Online Comment

Application H14-0165-21
Location Land off Wardentree Lane Pinchbeck Spalding PE113UG
Proposal Erection of 96 dwellings and associated works - outline approval H14-0720-18

Name Angela Doherty
Address Housing Strategy

Date Submitted 04-03-21
For/Against Comments

Drawing:
Planning Site Layout

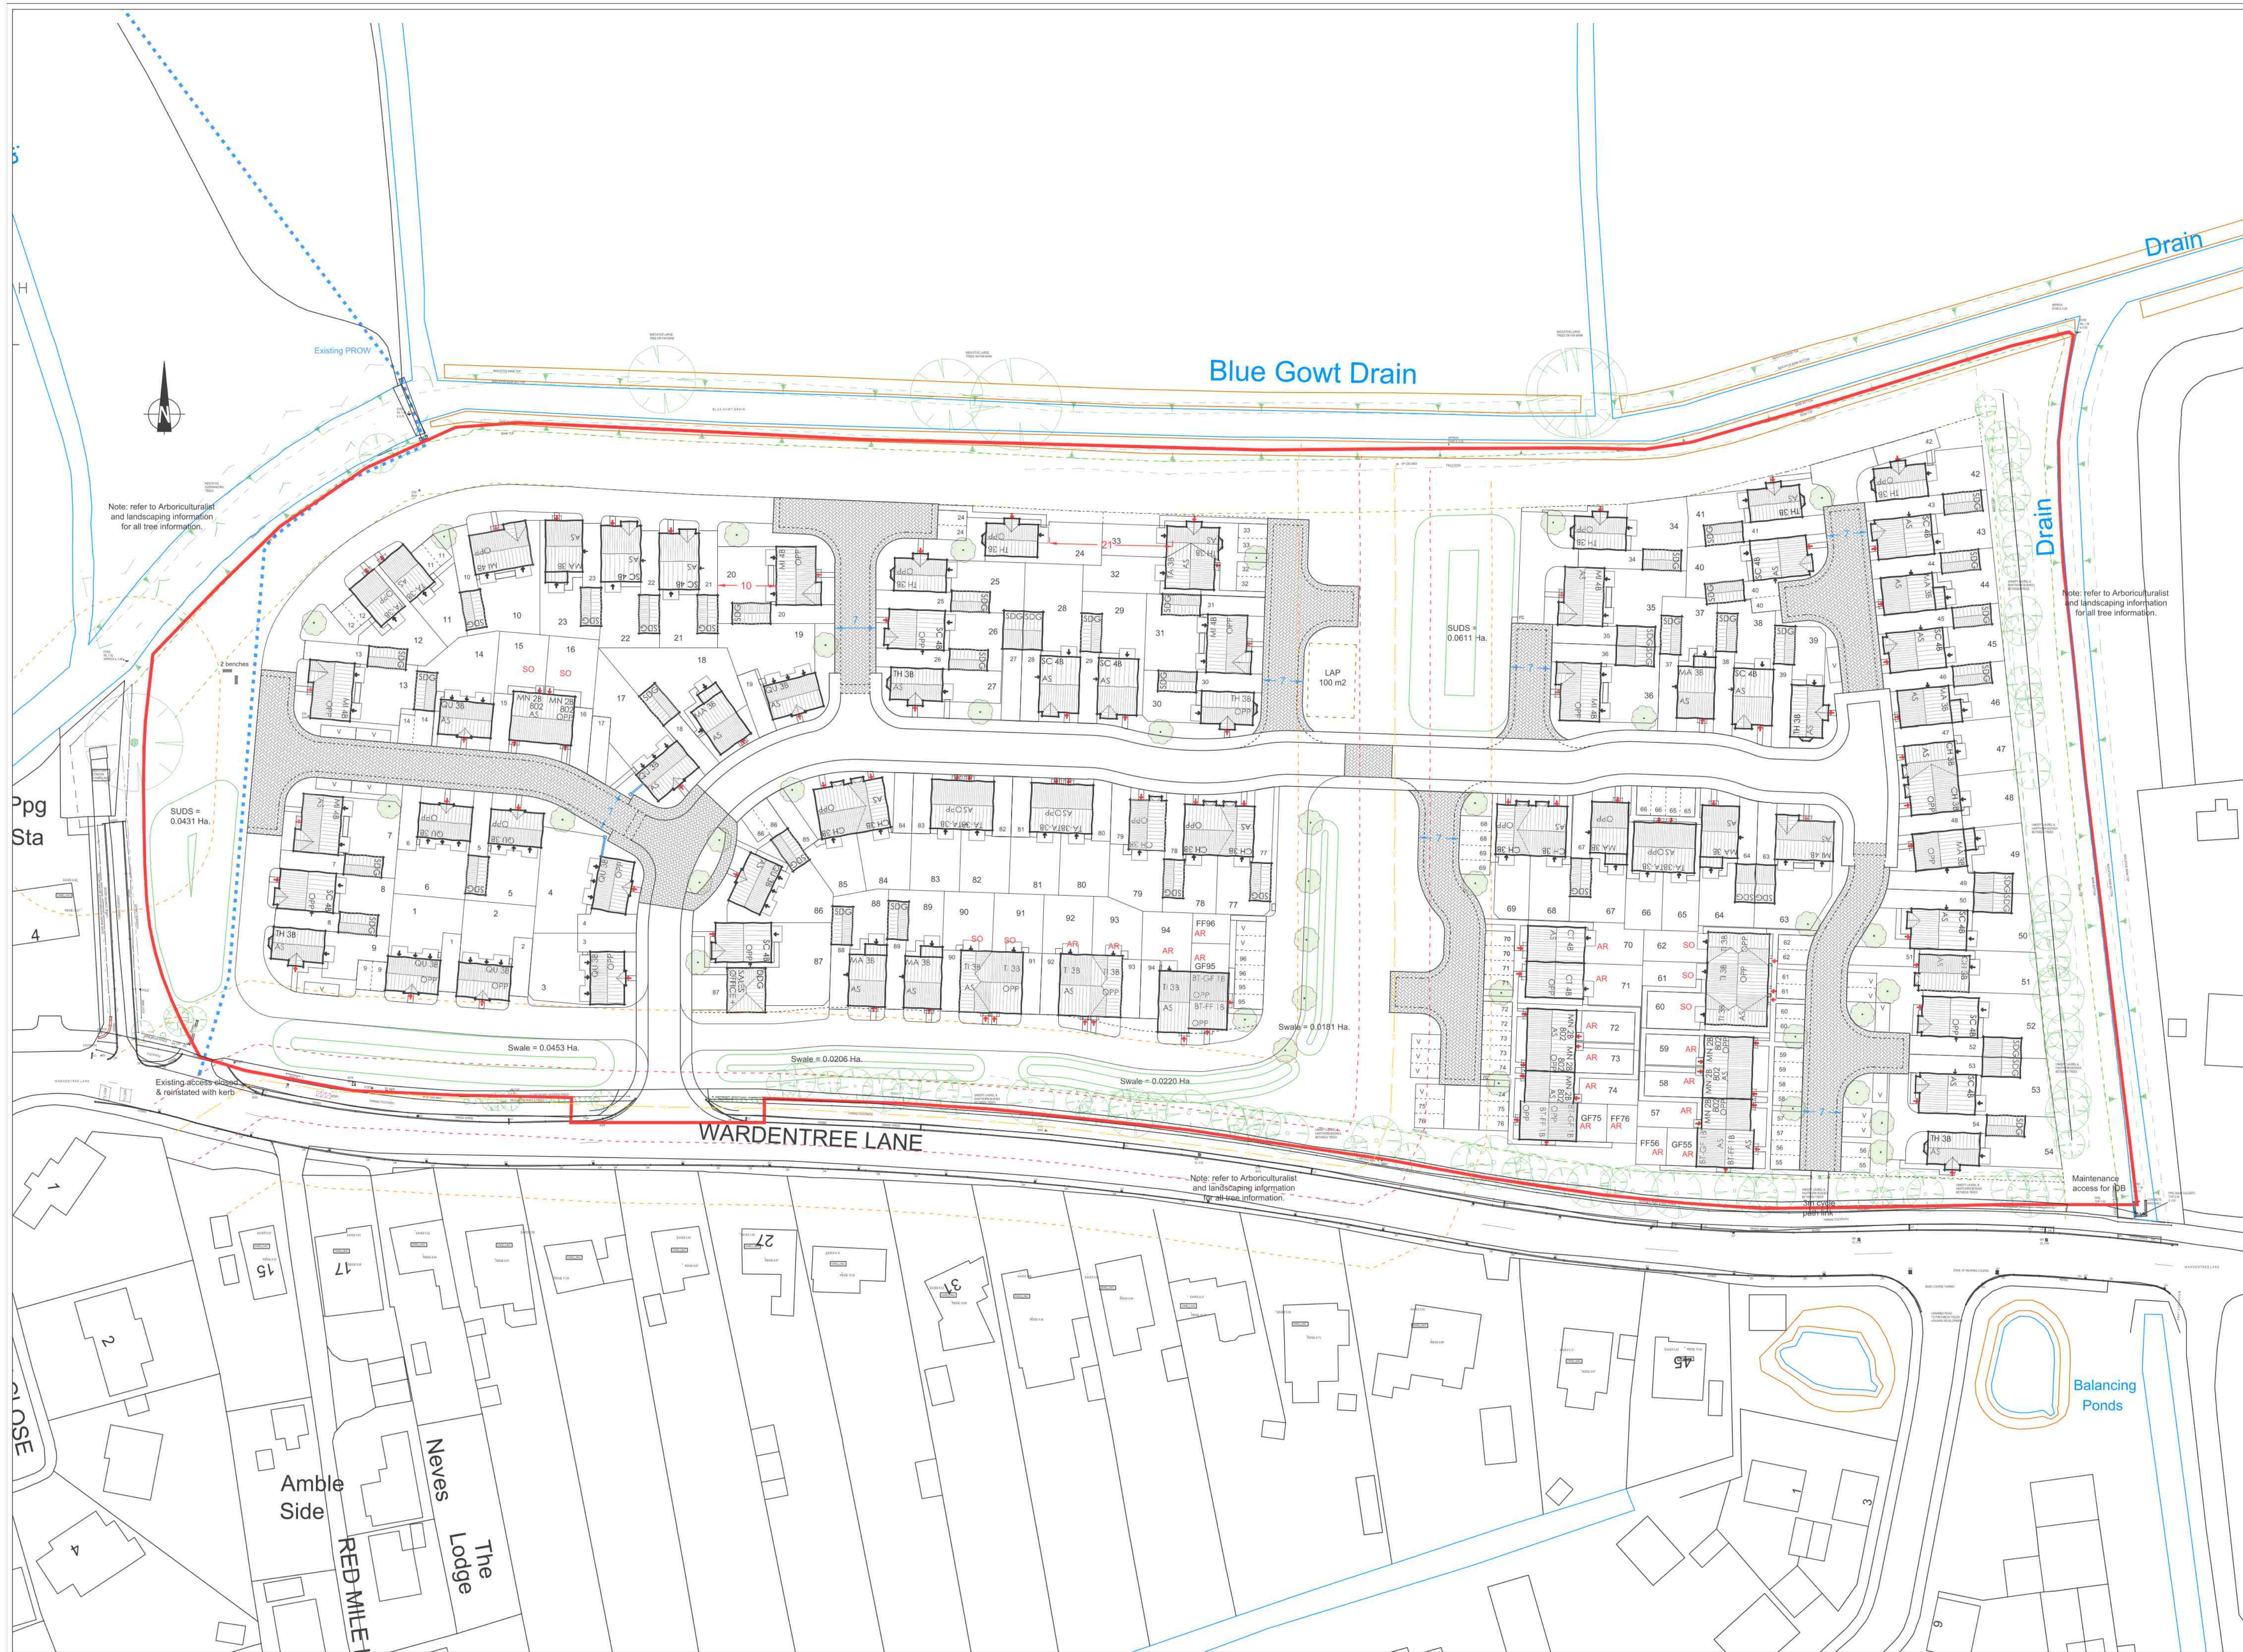
For the Rented mix the applicant proposes 6 x 1 bed maisonettes 6 x 2 bed maisonettes, 3 x 3 bed houses and 2 x 4 bed houses. The property sizes in terms of the number of bedrooms broadly accords with the recommended mix in the Strategic Housing Market Assessment, however it would not be recommended for the 2 bed dwellings to comprise of maisonettes directly above the 1 bed maisonettes given that households with children are likely to occupy the 2 beds and this may present management issues specifically in relation to noise levels. It would be preferable for both the 1 and 2 bed dwellings to be provided as houses as opposed to maisonettes (flats) with their own private gardens. If this is not possible due to the space restrictions of the site, then as a compromise the 1 beds could remain as maisonettes with the 2 beds provided as houses.

For the Shared Ownership mix the applicant proposes all 7 as 3 bed houses. It would be preferable if a number of 2 bed houses could be included as part of this mix, with a minimum of 3 x 2 bed houses and 4 x 3 bed houses. The applicant may also wish to consider providing a small number of 2 bed bungalows as part of the Shared Ownership mix to diversify the house types and contribute to meeting the needs of an ageing population.
